<b>Application Ref:</b>	3/2021/0508	 Ribble Valley Borough Council <a href="http://www.ribblevalley.gov.uk">www.ribblevalley.gov.uk</a>
<b>Date Inspected:</b>	14/06/21	
<b>Officer:</b>	RB	
<b>DELEGATED ITEM FILE REPORT:</b>		<b>APPROVAL</b>

<b>Development Description:</b>	Proposed single storey rear extension and two dormer windows to rear.
<b>Site Address/Location:</b>	4 Loach Field Close, Hurst Green, BB7 9ZF

PROPOSED REAR ELEVATION

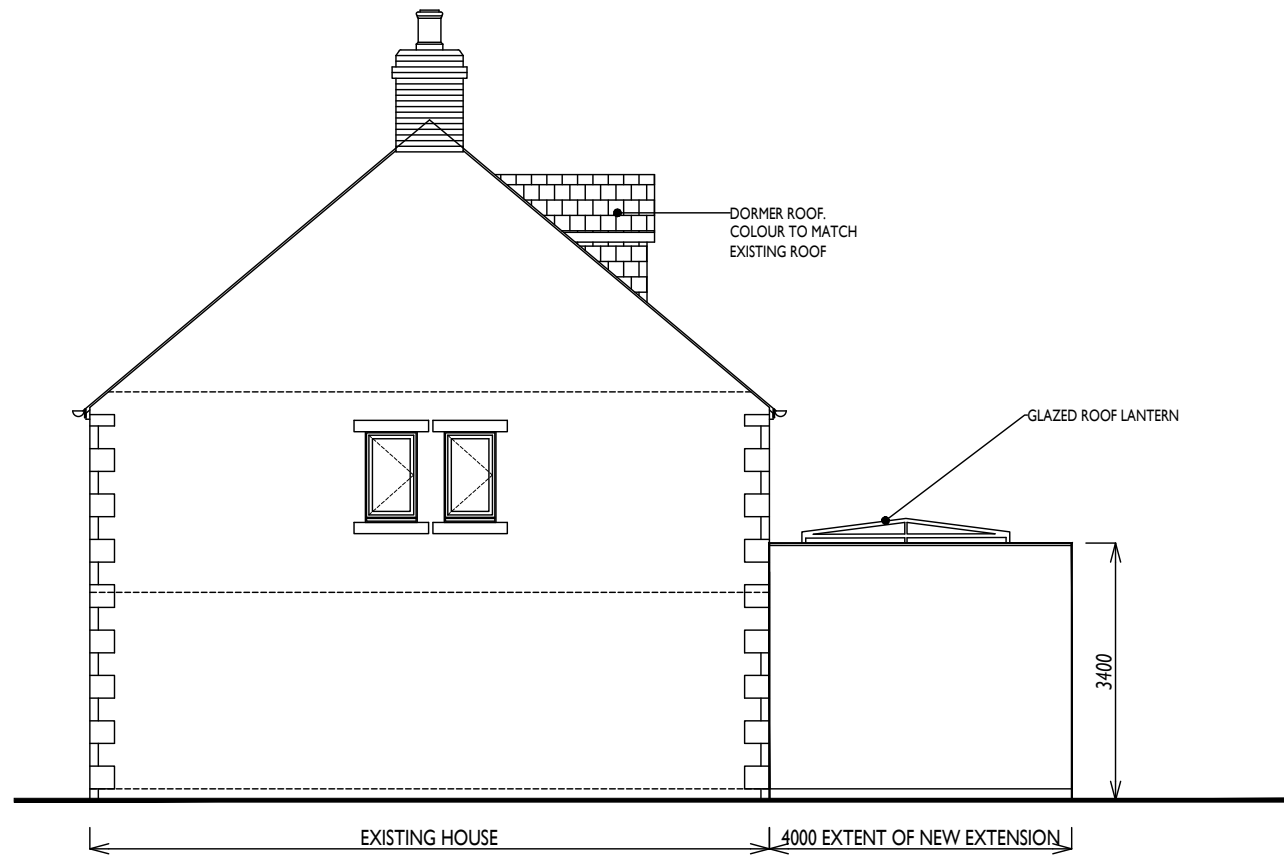
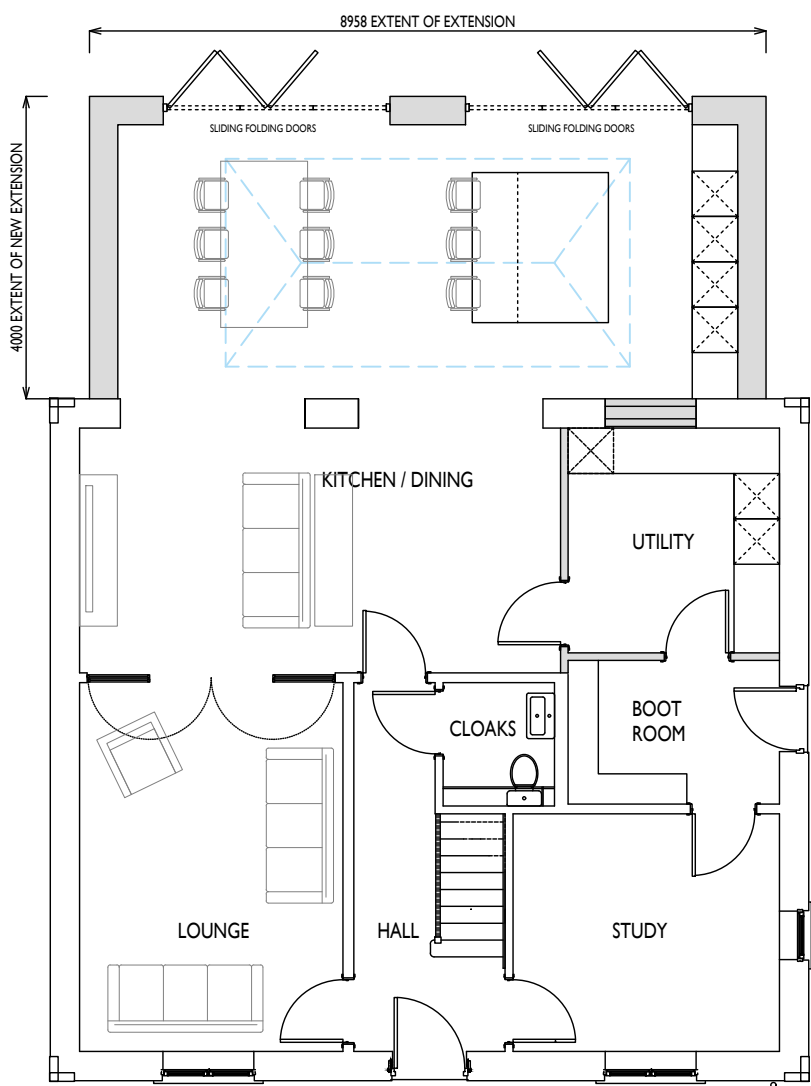
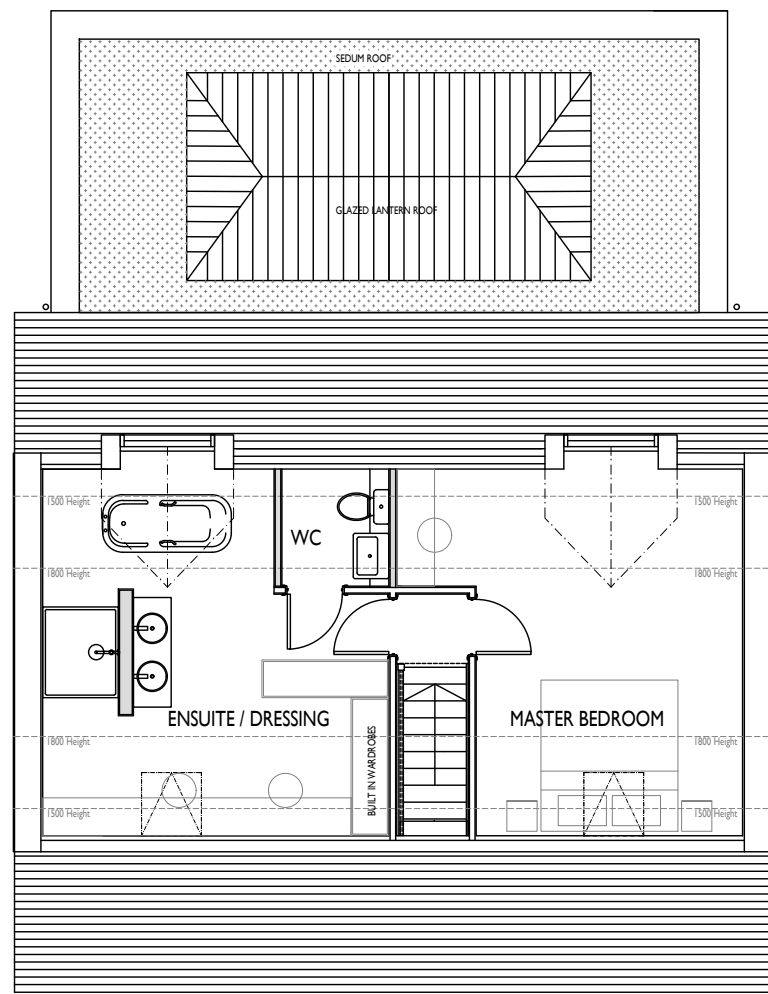
The application property is a newly erected dwelling within a new housing site known as The Warren. The properties on the development site are all a similar style but do differ slightly. The dormer windows have been amended as they were originally submitted to have a flat roof dormer between linking the two pitched roof dormers. It was considered that the dormer would result in an incongruous feature that would be harmful to the visual amenity of the area. The proposed dormers as amended whilst not found on this house type would have an acceptable impact on the visual amenity of the area as they do not dominate the rear roof slope and dormers are present on other properties in the immediate area.

The proposed rear extension will remain subservient to the main house as it has been reduced to having a rearward projection of 4m and is single storey. The rear of the property is visible from views to the north of the site however due to the topography of the land only the roof of the extension would be visible. As such the design and use of glazing to the rear is considered to have limited impact on the visual amenity of the AONB.
